**WELWYN HATFIELD BOROUGH COUNCIL
EXECUTIVE DIRECTOR - PLANNING, PUBLIC PROTECTION AND GOVERNANCE**

DELEGATED APPLICATION

Application No: 6/2017/0256/HOUSE
Location: 10 Hill Rise Cuffley Potters Bar EN6 4EE
Proposal: Erection of brick wall and gate in front garden following the removal of existing timber fence
Officer: Mr R Adenegan

Recommendation: Granted

Drawing Number: AC/201 Revision:

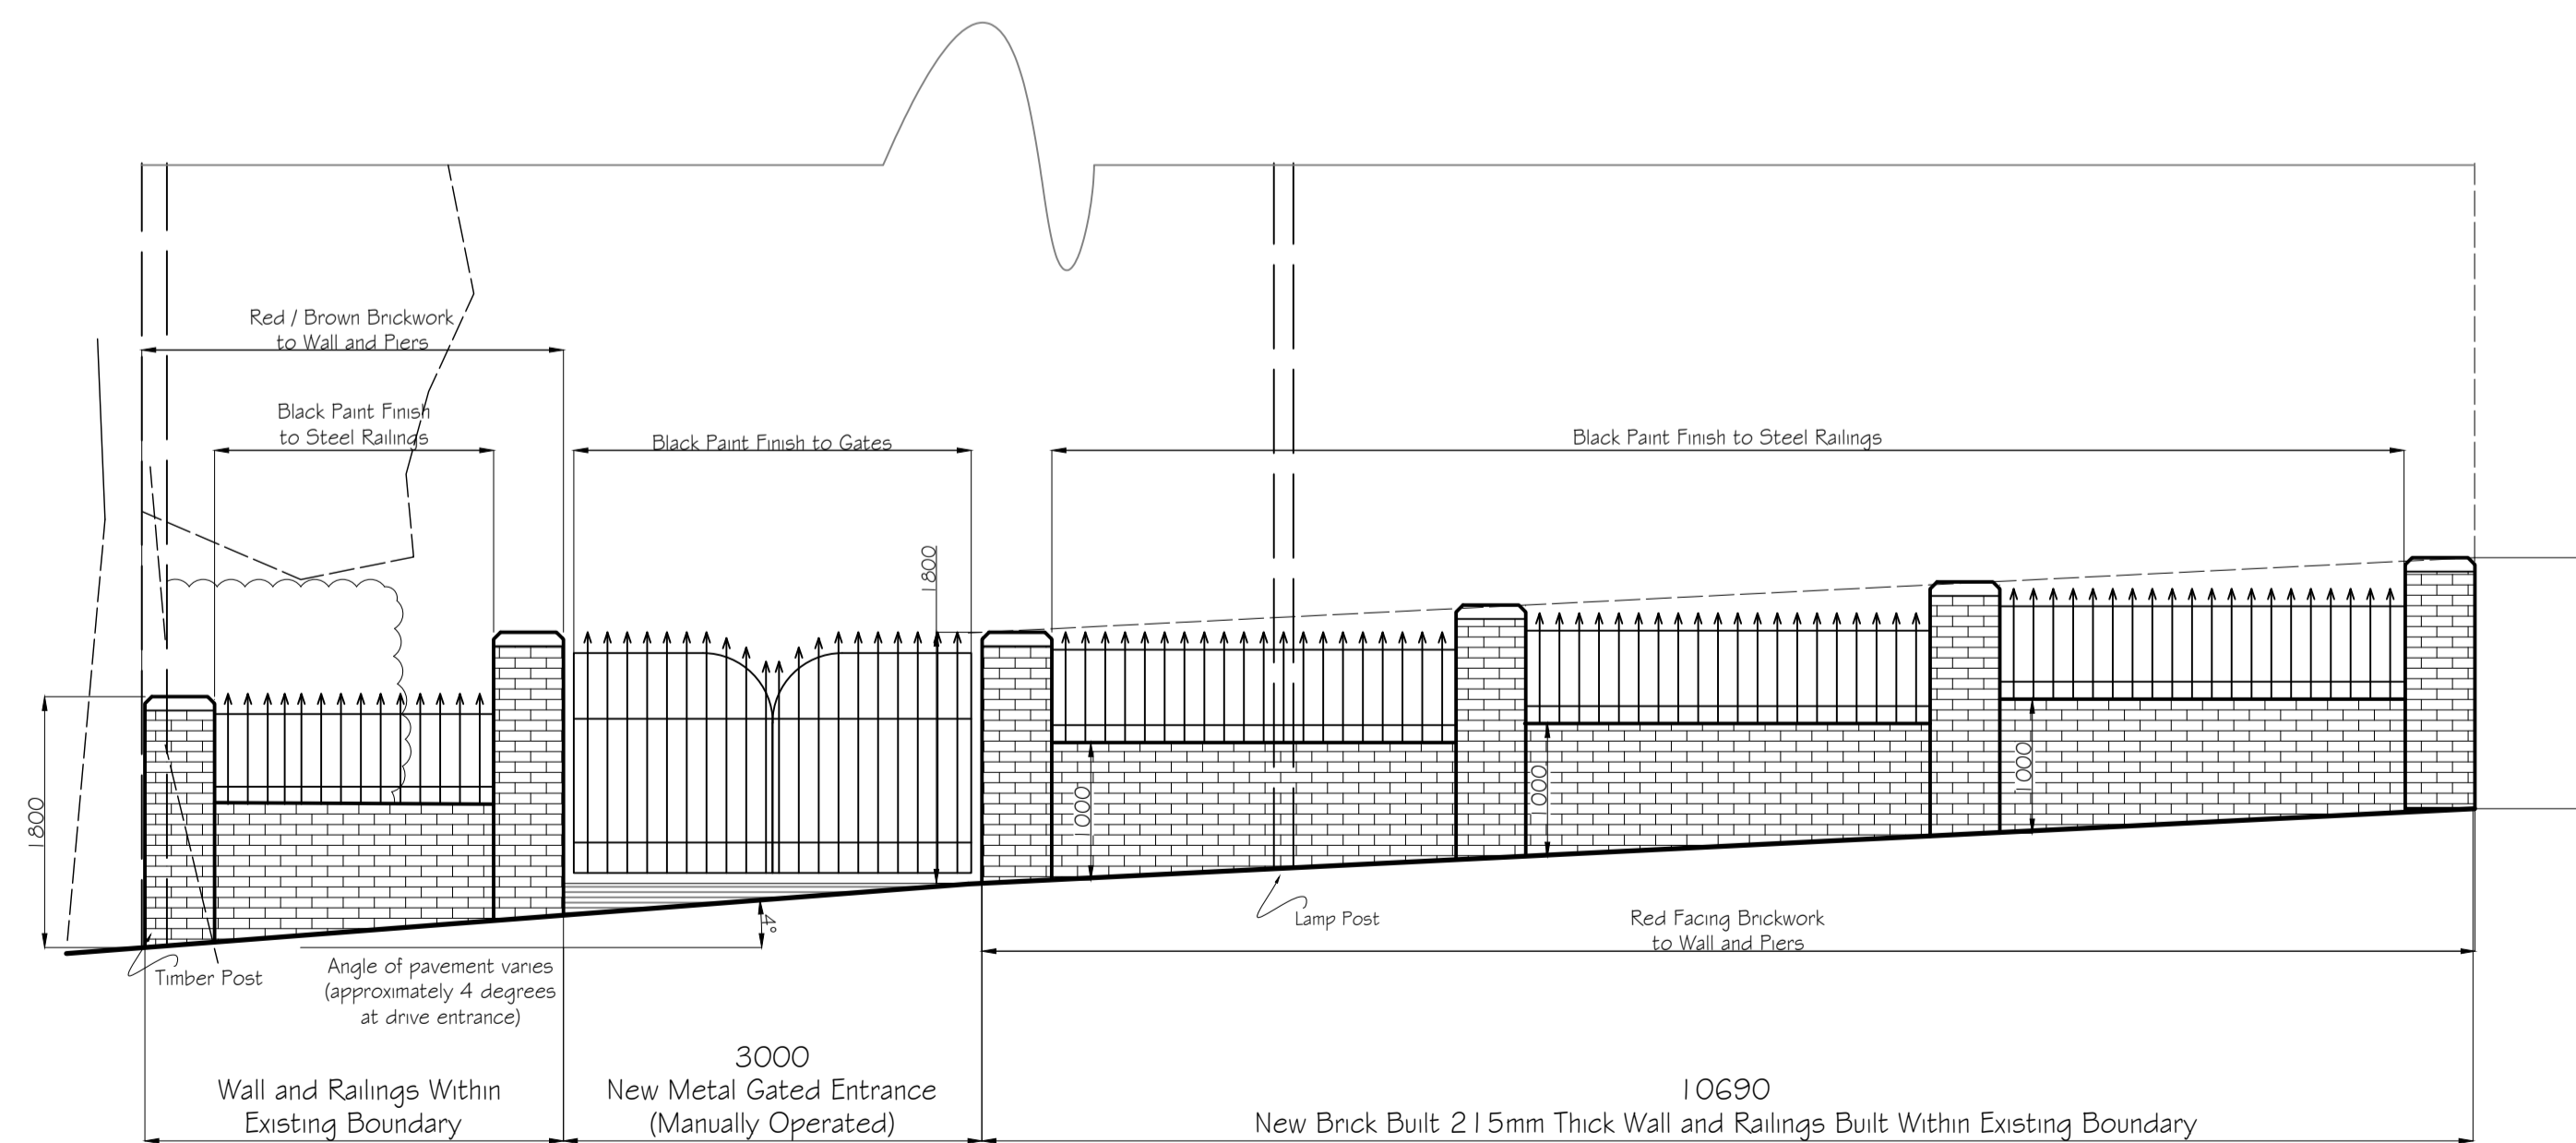
Comment (if applicable):	
Would the development reflect the character of the area?	
<input checked="" type="checkbox"/> Yes <input type="checkbox"/> No	
Comment (if applicable): Policy D1 and D2 require development proposals to respect and relate to the character and context of the area. They should maintain or enhance and improve the character of an existing area.	
<p>The frontages of the neighbouring properties vary with boundary treatments that differ in design, but are mainly open or have low brick walls. Hedges and vegetation also make up the boundary treatments for several of the neighbouring properties.</p> <p>The frontages of this part of Hill Rise are characterised by open, low wall and hedges. However, Hill Rise has examples of similar front boundary treatments as being proposed at Nos. 19, 21 and 23 Hill Rise. The property at No.23 Hill Rise benefited from planning permission S6/2009/1012/FP which supported brick columns at a height of 1.86m in height whilst that of No. 19 benefitted from planning permission reference S6/2010/0238/FP which supported brick columns of approximately 1.92m high. The current proposal is approximately 1.8m high and so would not be significantly different. In addition, No. 4 Hill Rise, has railing gates of some 2m high along its front boundary with brick columns of similar height.</p> <p>The proposed fence has been designed to step down the hill to incorporate the changes in level. The new wall and railings would extend for approximately 17m (a similar distance to that across the road at No.23) with the brick columns and railings being slightly lower.</p>

It is considered that the use of open railings above the wall will still allow views into the application site and would not be significantly dissimilar to that which was approved at Nos. 19, 21 and 23.

The principle of a low brick wall or low railings is not out of keeping with the character of the road as it is reflective of similar front boundary walls in the street. The proposed works will respect the character, appearance and setting of the building in terms of design and scale and would not detract from the character of the surrounding properties. The use of railings with low wall would afford an open frontage characteristic of properties in the street.

Comment (if applicable): The proposed gate would be set approximately 2.8m behind (visibility splays) the public pavement with the gates opening inward into the front garden providing a visibility for drivers of vehicle leaving the site. Car existing and entering the application site would be able to wait and not obstruct vehicular and pedestrian flow. Thus the proposal does not present a safety hazard for pedestrians.

1. The brickwork, and other external materials to be used on the development hereby approved must match the existing dwelling/building in relation to colour .
